DECISION DELEGATED TO HEAD OF PLANNING

Application No: H09-0305-23 **Applicant:** University Academy Holbeach

Proposal: Construction of detached portal frame double height building & associated works - approved under H09-1181-22. Modification of Condition 2 to allow amendments to previously approved plans.

Location: University Academy Holbeach Park Road Holbeach

DRAWING Existing & Proposed Site Plans

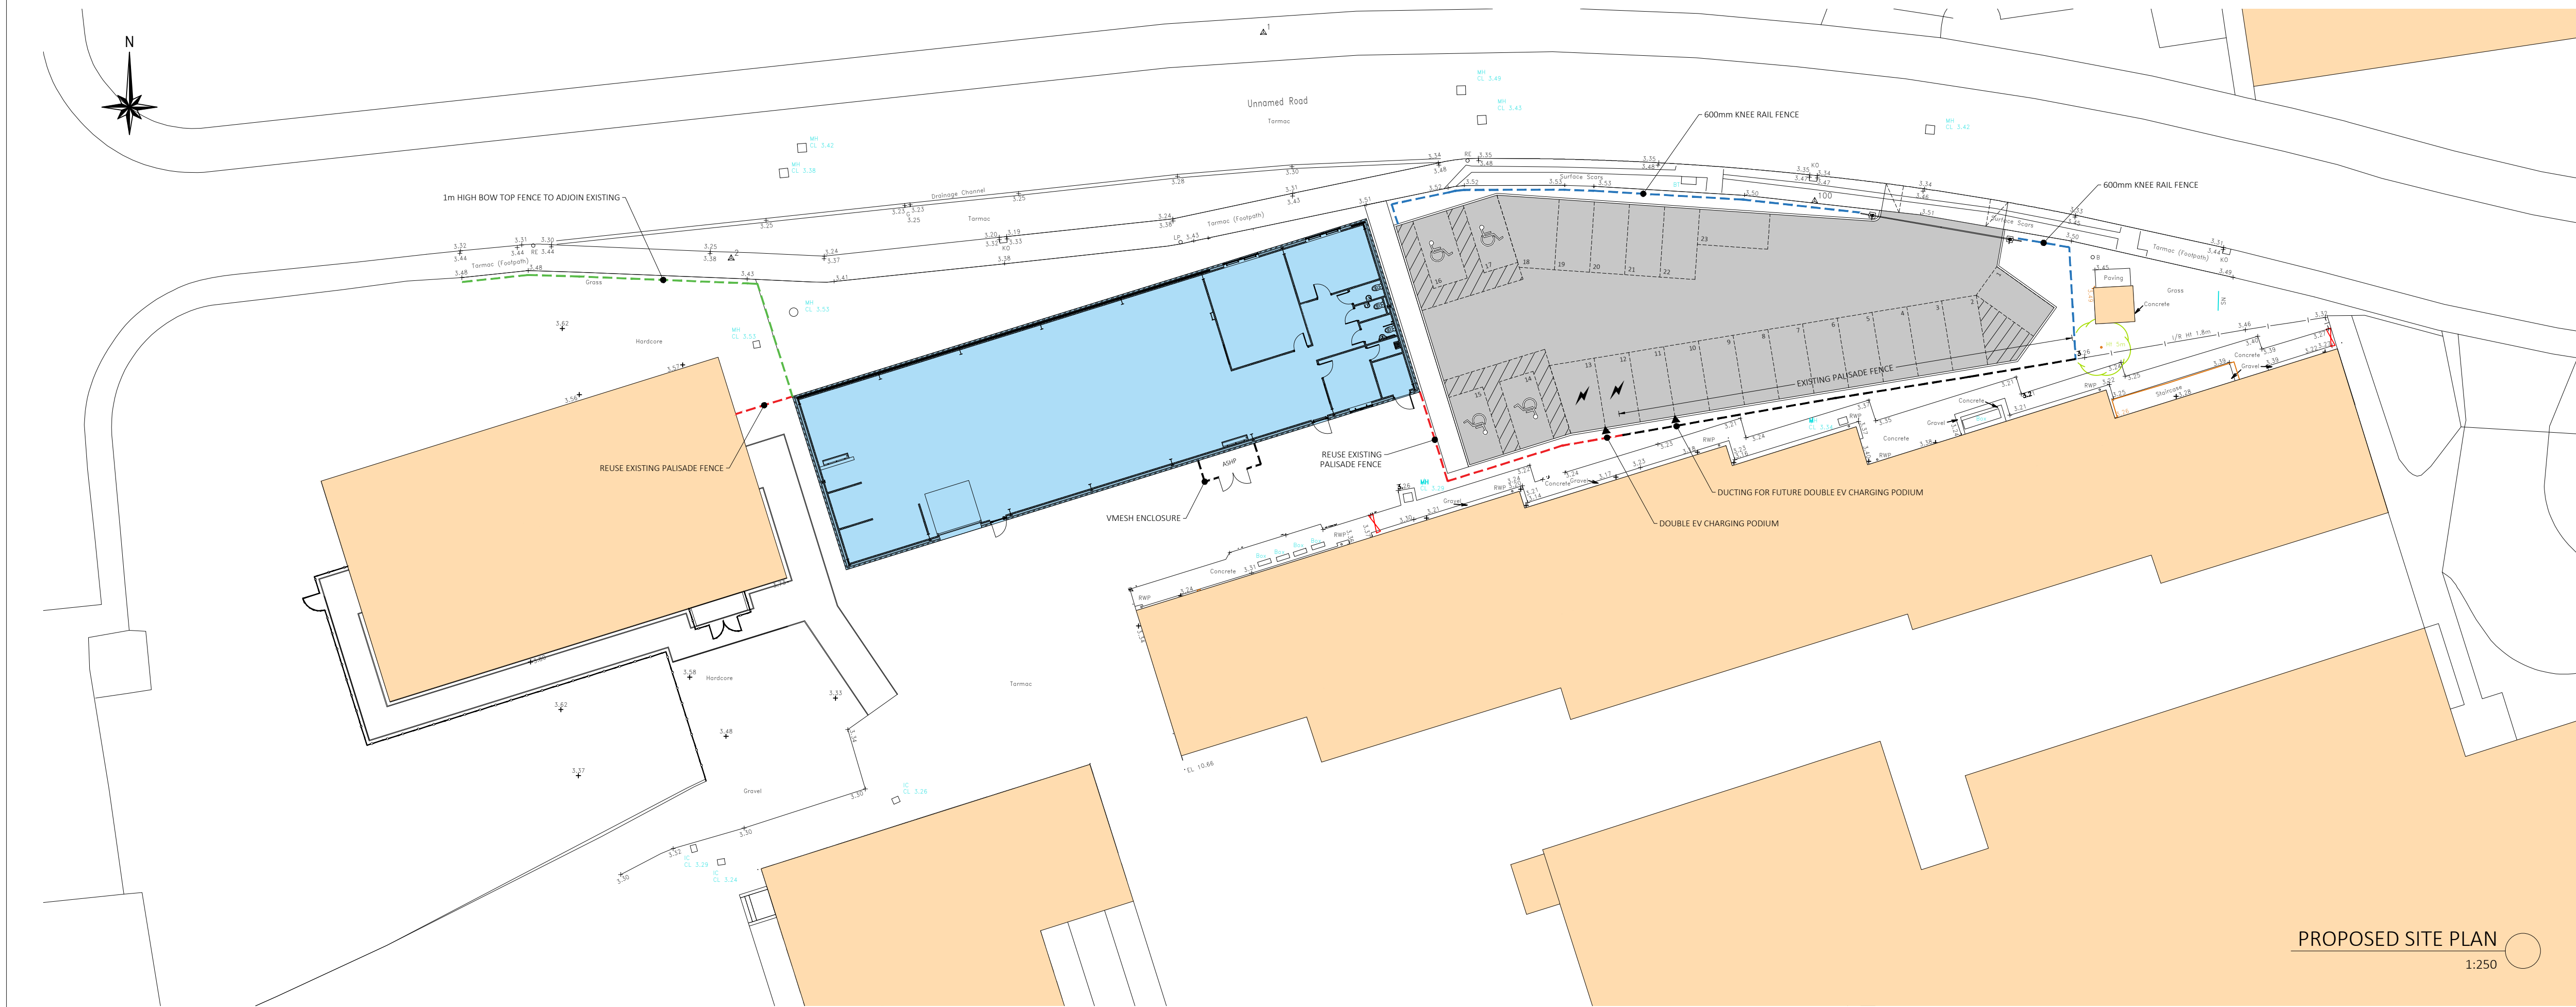
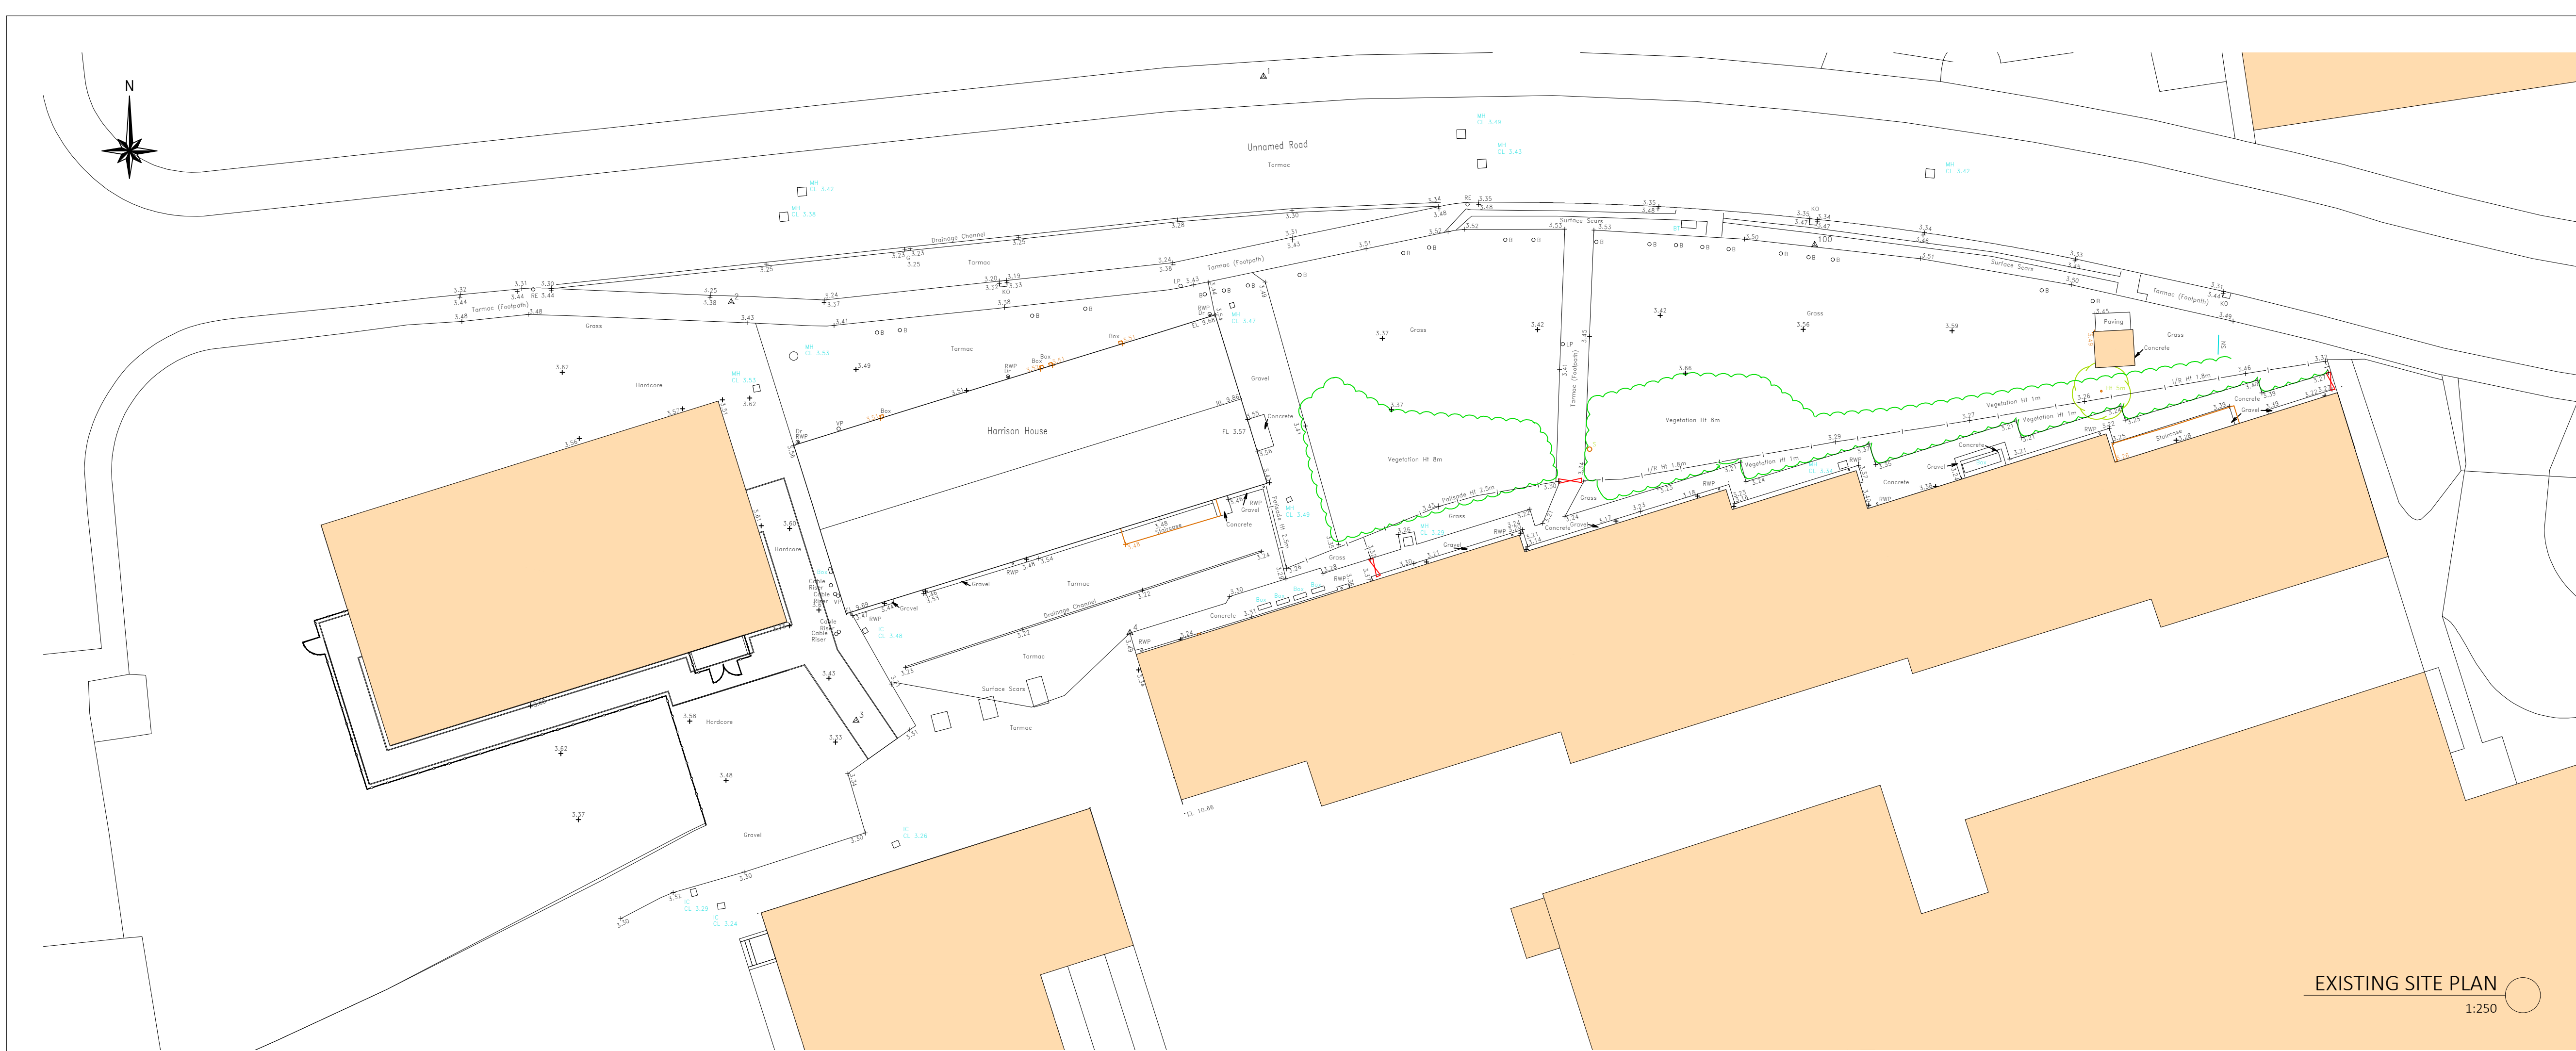
The new parking layout shows one less parking space to the 24 spaces previously shown on the

previously approved plans. This can be accepted as under the 2018 planning permission for the maths block, 44 parking spaces were required to be created on the land in question. The current scheme proposes 23 parking spaces with an additional 35 spaces previously approved west of the site therefore there would be an overall increase in the number of parking spaces. Given there is no increase in staff numbers proposed, the development is considered to meet the current parking standards.

Proposed Floor Plans

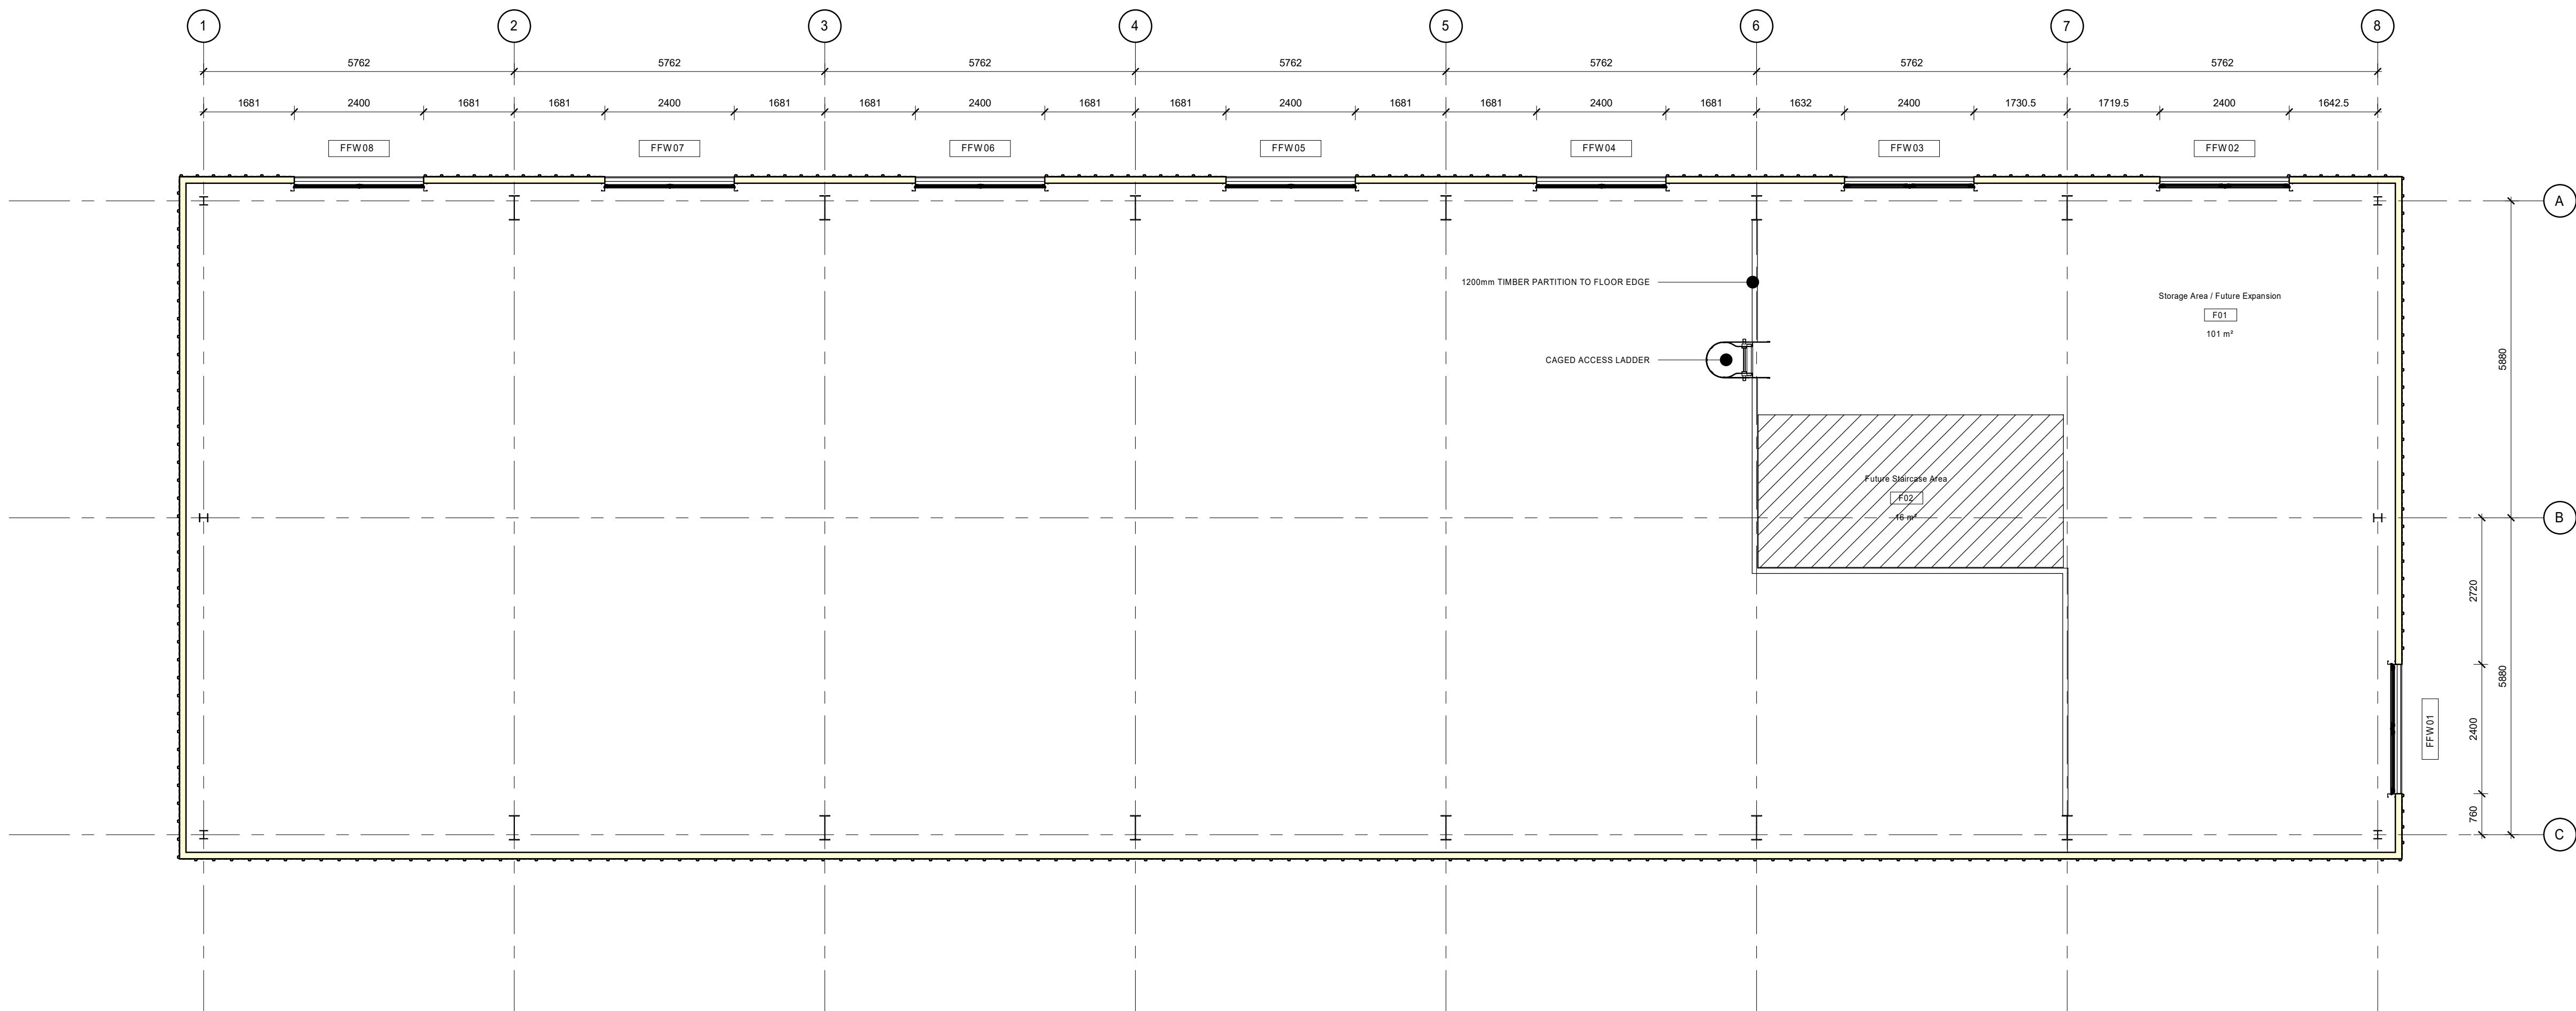
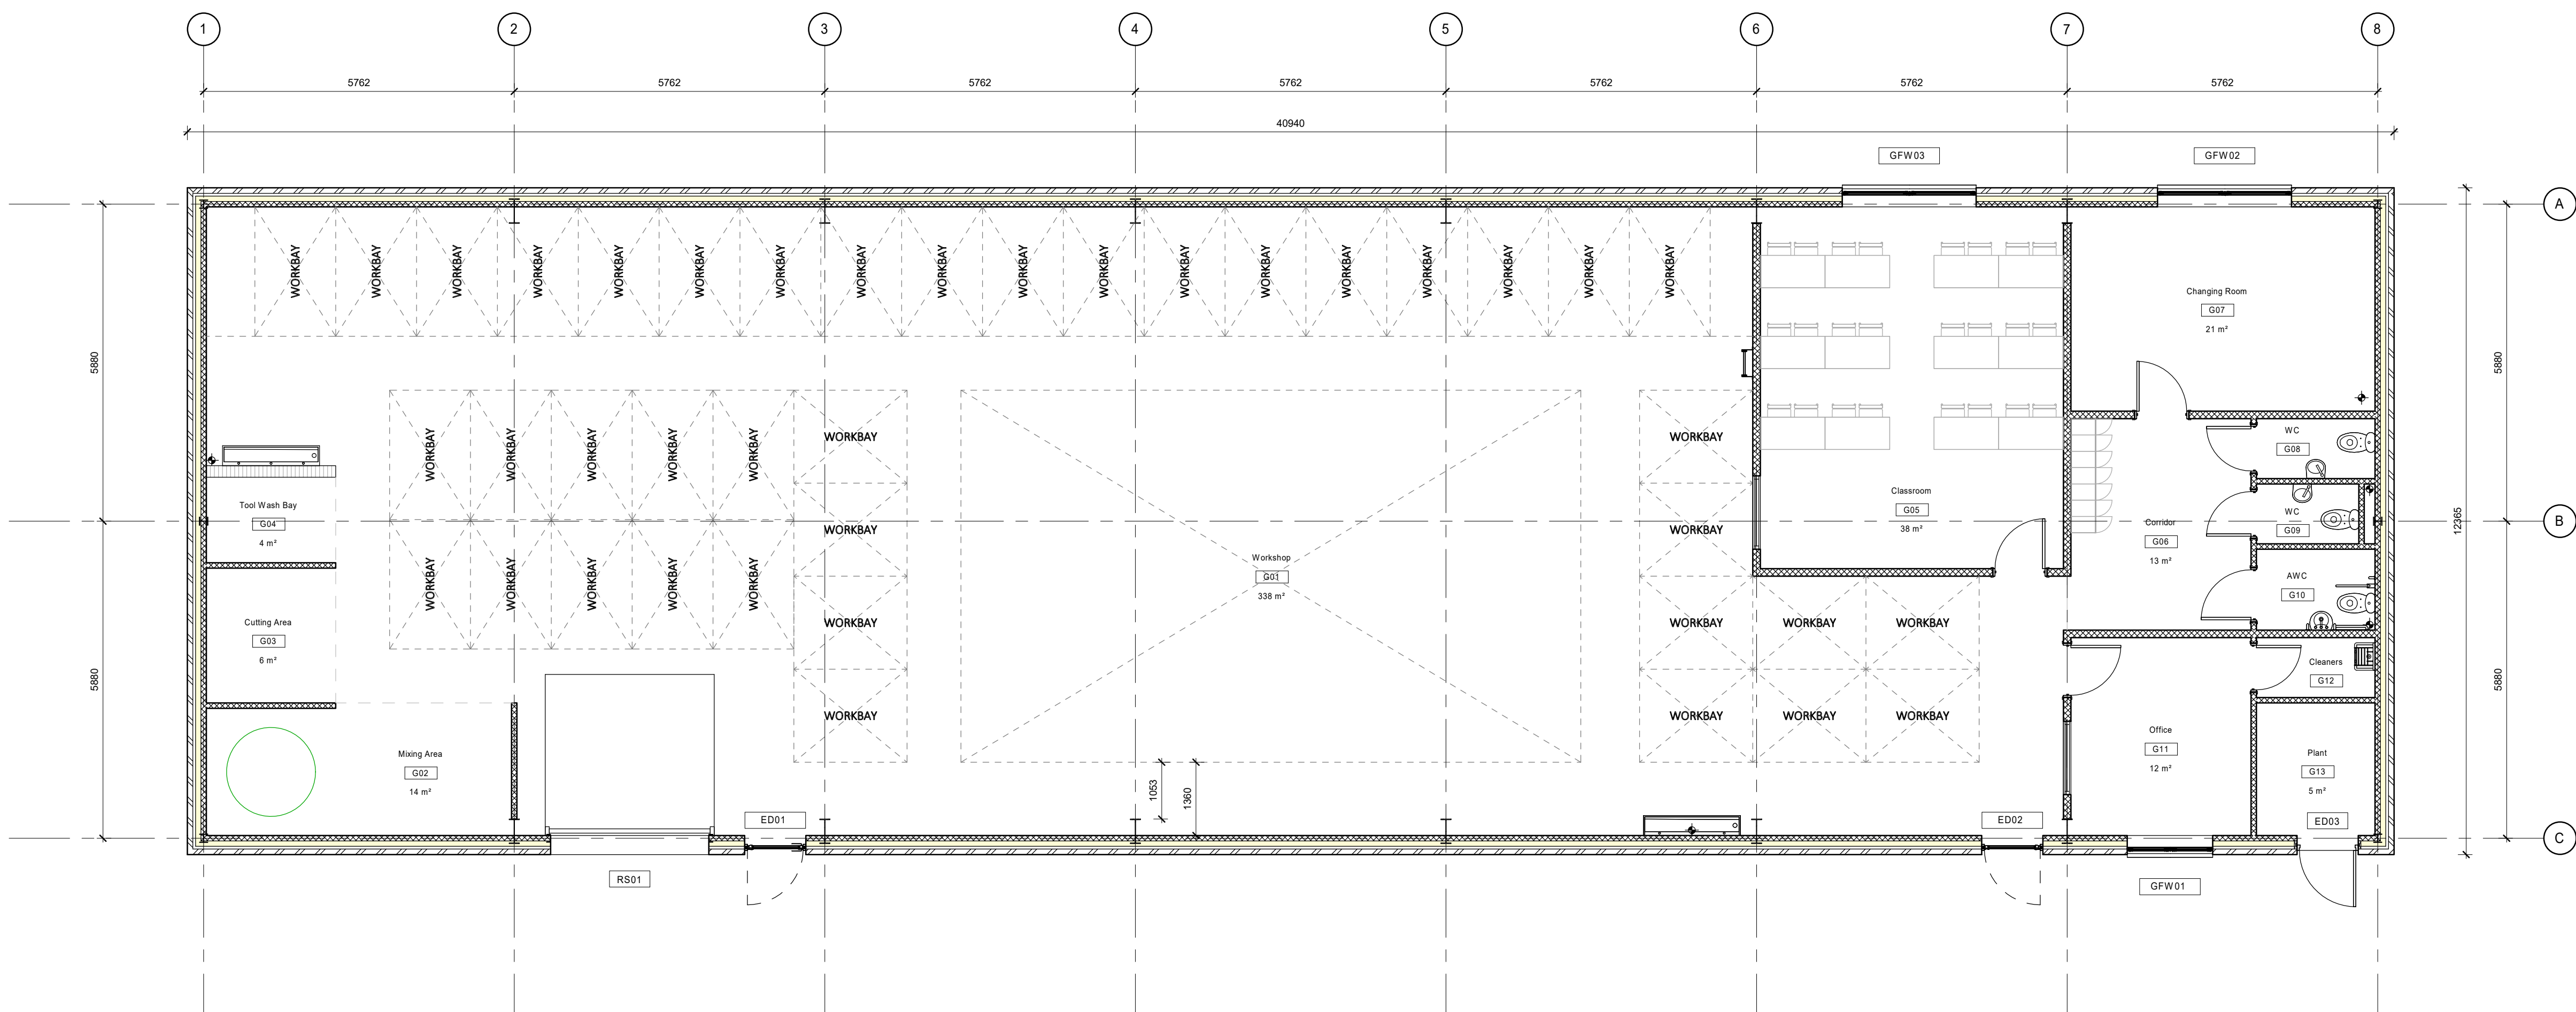
- 2no high level window openings in the northern elevation
- 1no new window opening and repositioning of 3no doors on the southern elevation
- Internal layout alterations
- Alterations to parking layout and reduction in parking spaces from 24 to 23
